**SSD 6626 - SICEEP Darling Square - Mixed Use
Residential Building within North-East Plot**

**Submission
OBJECTION**

21 November 2014

21st June, 1pm

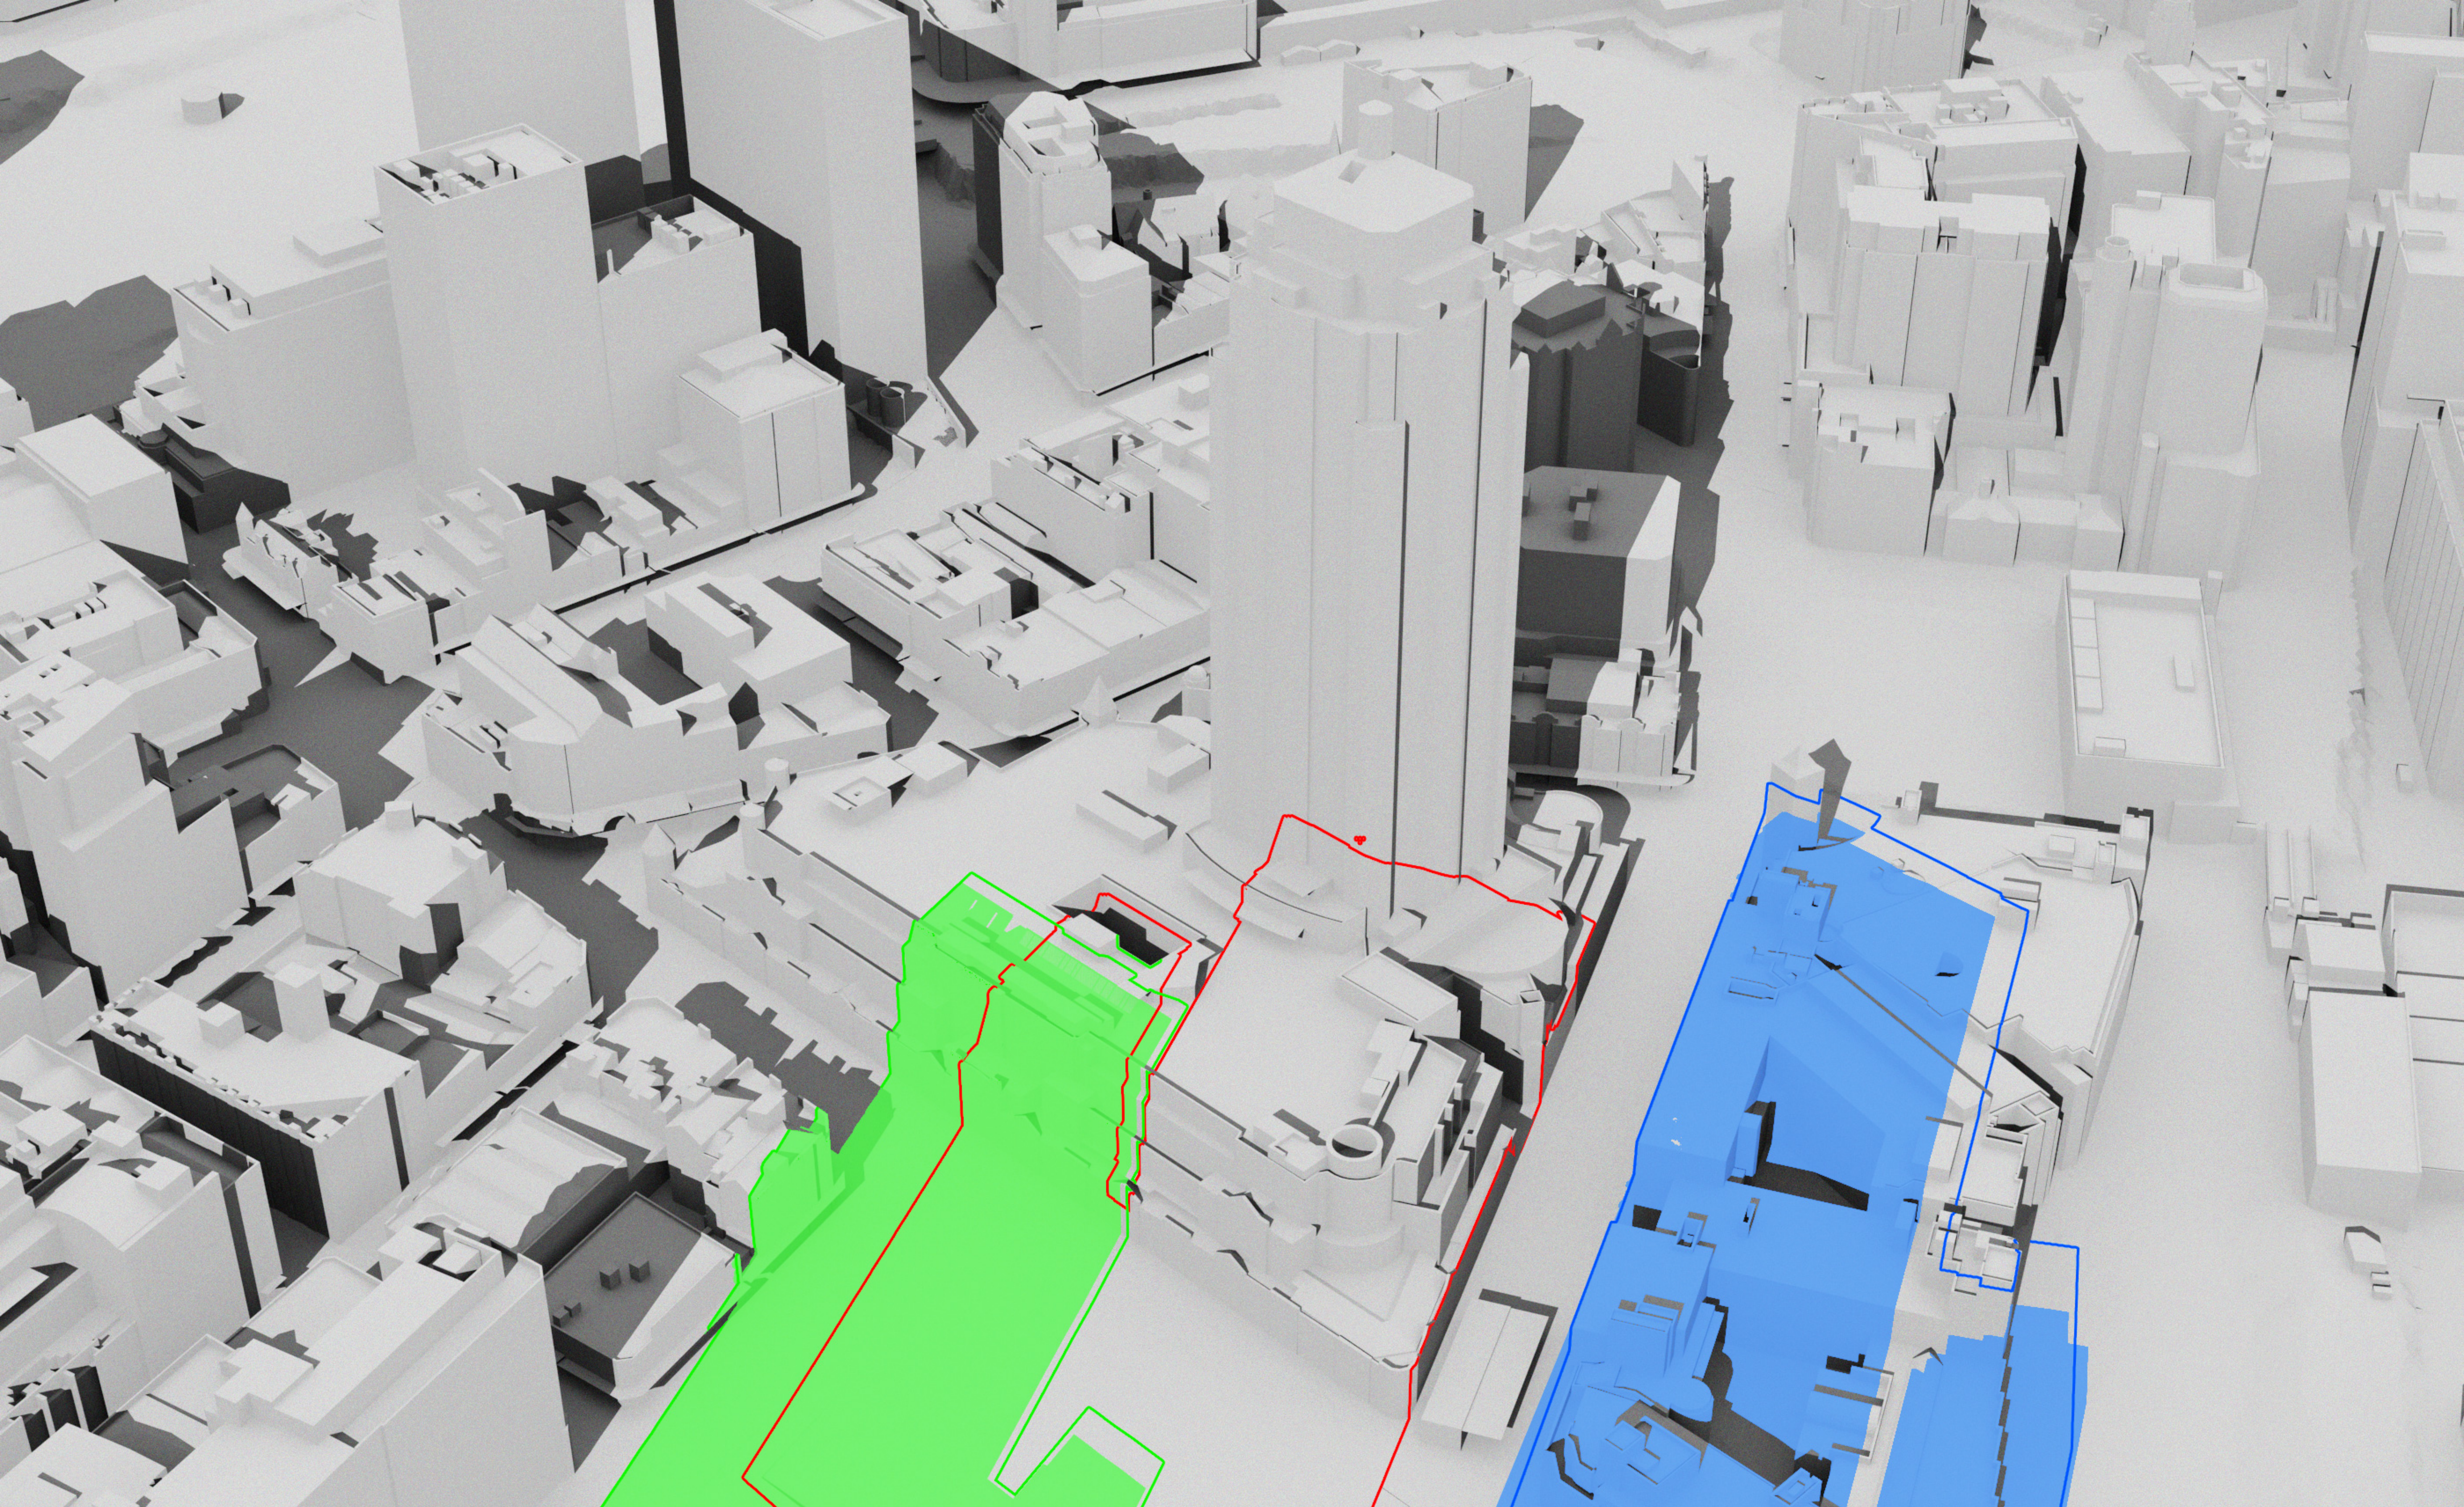
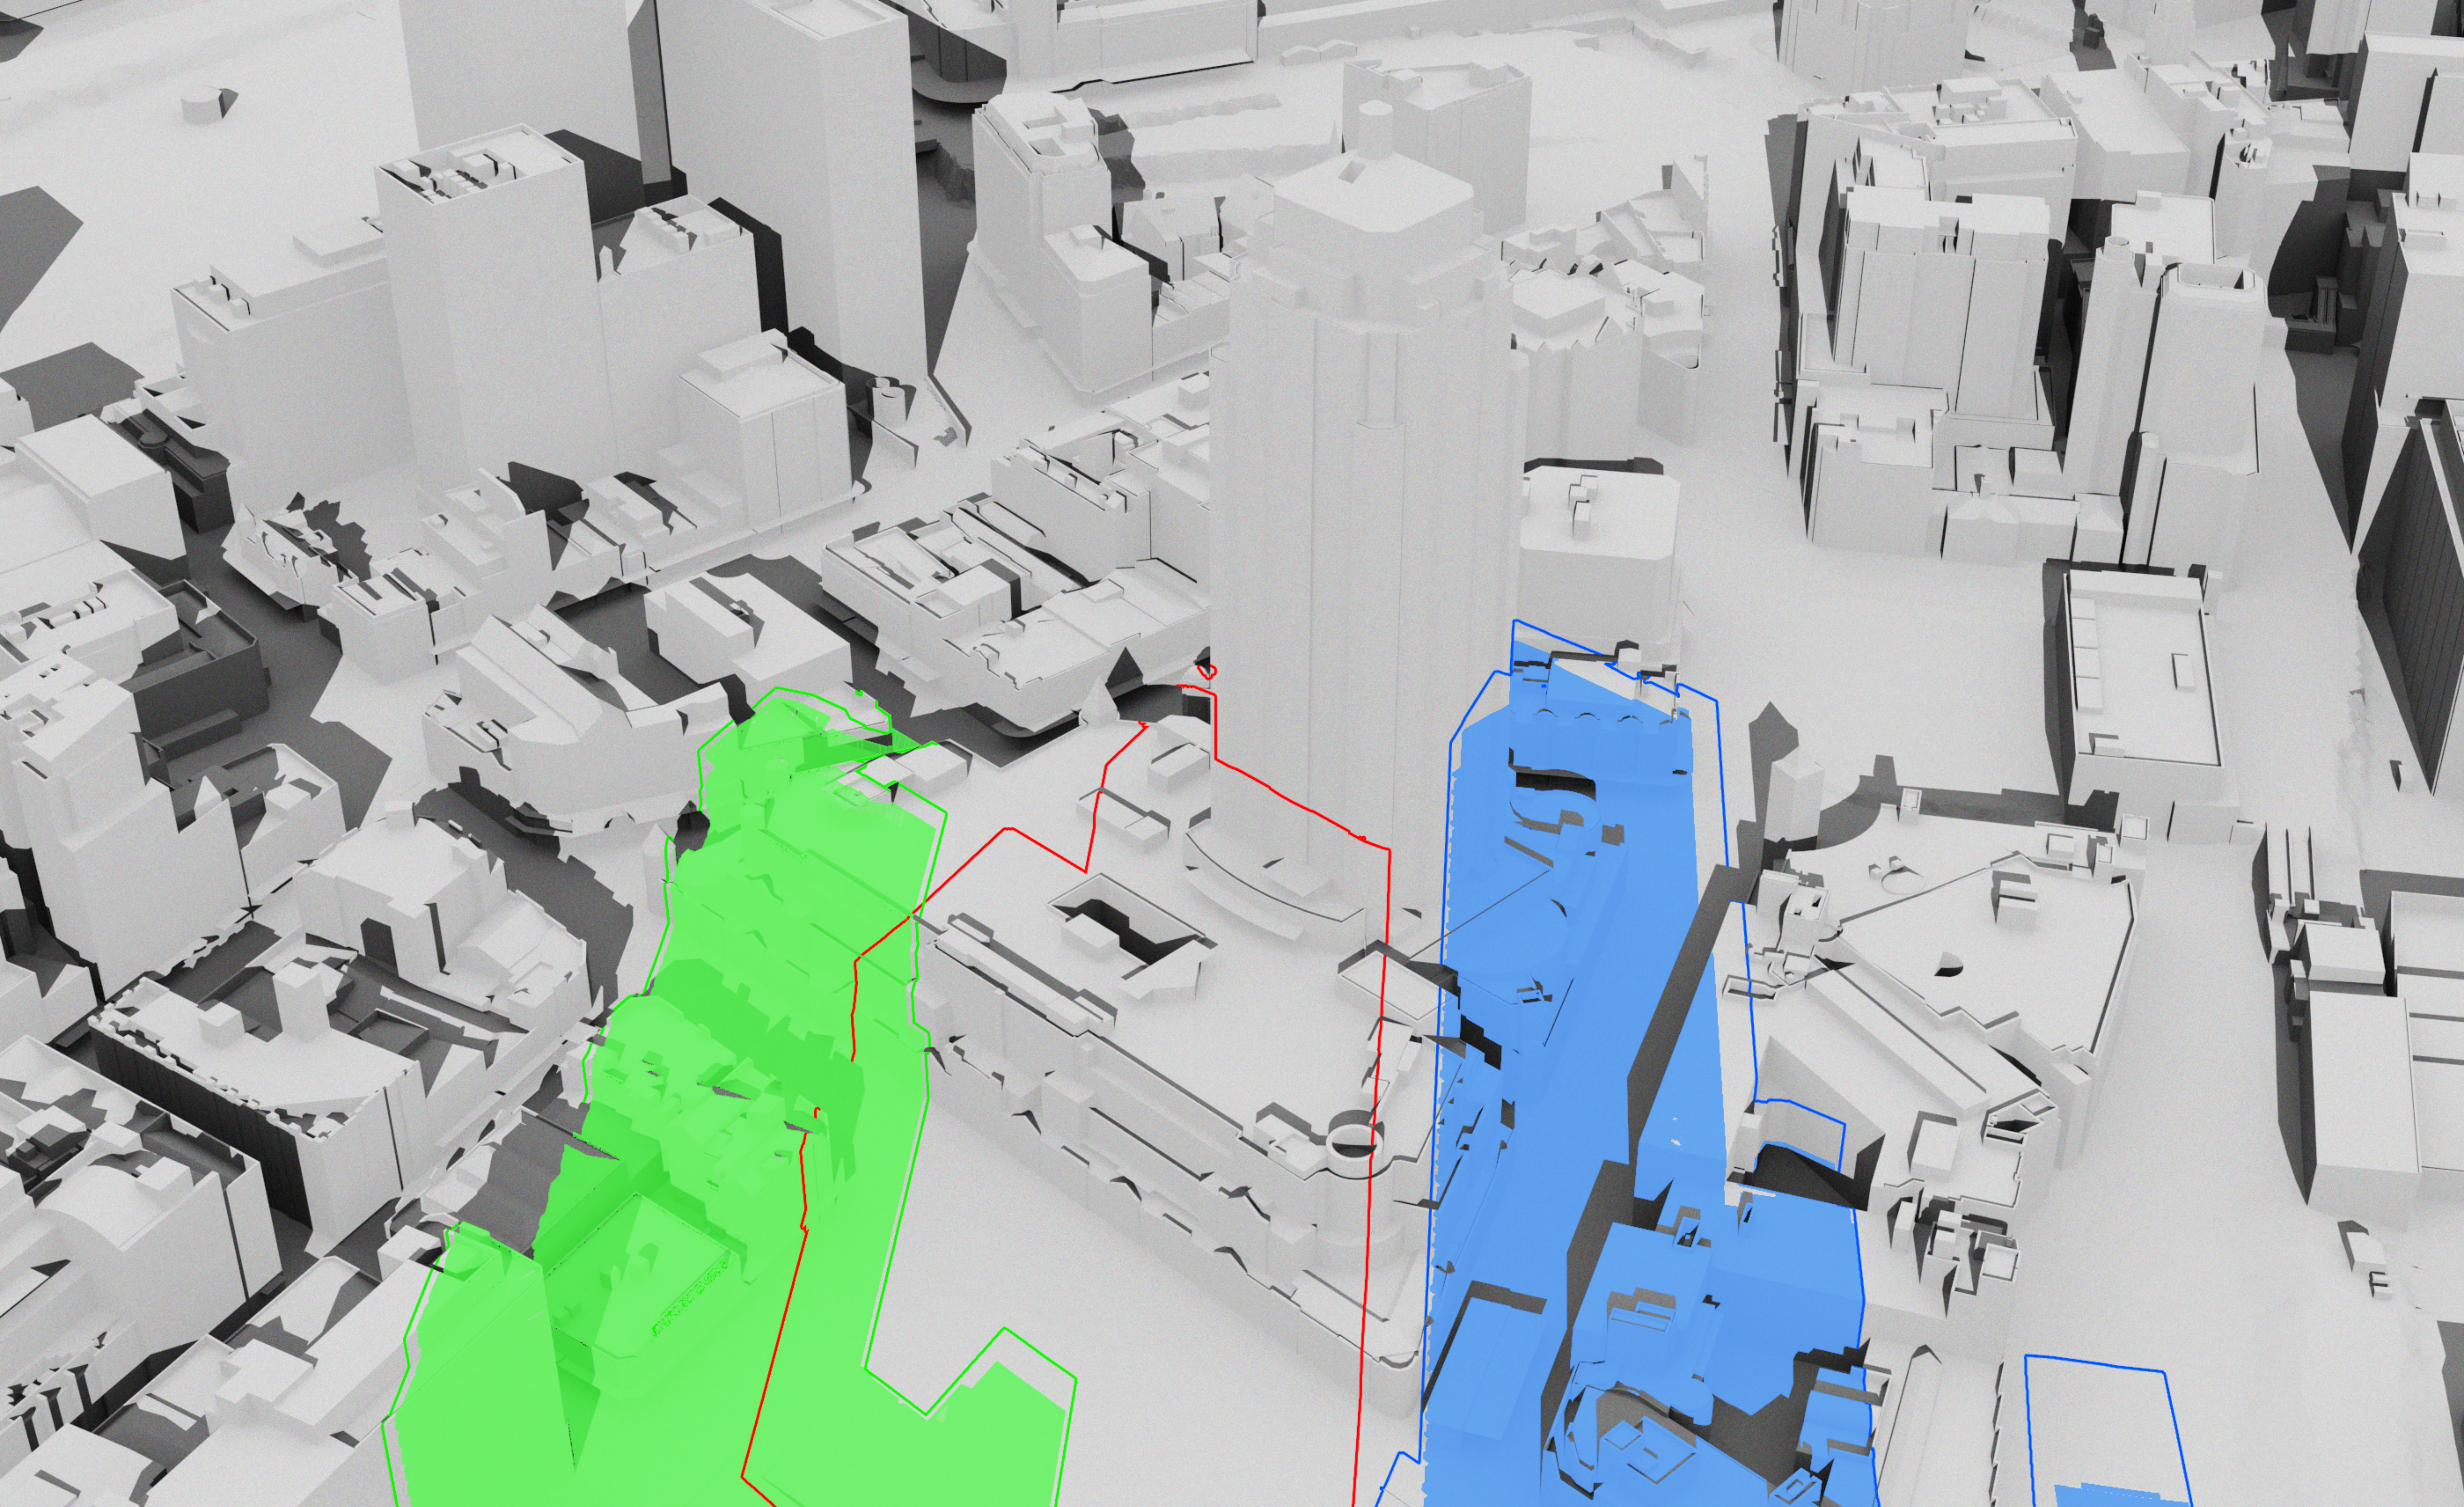
With respect to the podium of The Peak Apartments, the EIS states that " The landscaped podium associated with The Peak Apartments will continue to receive at least two hours of solar access, ensuring compliance with the intent of the Sydney DCP 2012.". Although this statement is true, two hours is a major reduction from the existing 21 June daylight access of about six hours.

Excessive overshadowing of The Peak apartments

There is no overshadowing of apartments in The Peak by the NE plot. The overshadowing is by the SW plot being developed by the same proponent.

Excessive overshadowing of public open space - the new square - "Haymarket Square"

We agree with the City of Sydney's view that "excessive morning shadows are cast into the outdoor and café areas in the new square by new surrounding building edges. In order to improve morning sun access to the square in winter, it is recommended that the building heights lining the new square be reduced and the floor area relocated to the surrounding streets podium edges..." Source: City of Sydney, SSD 5878 (SICEEP) The Haymarket submission, page 34.
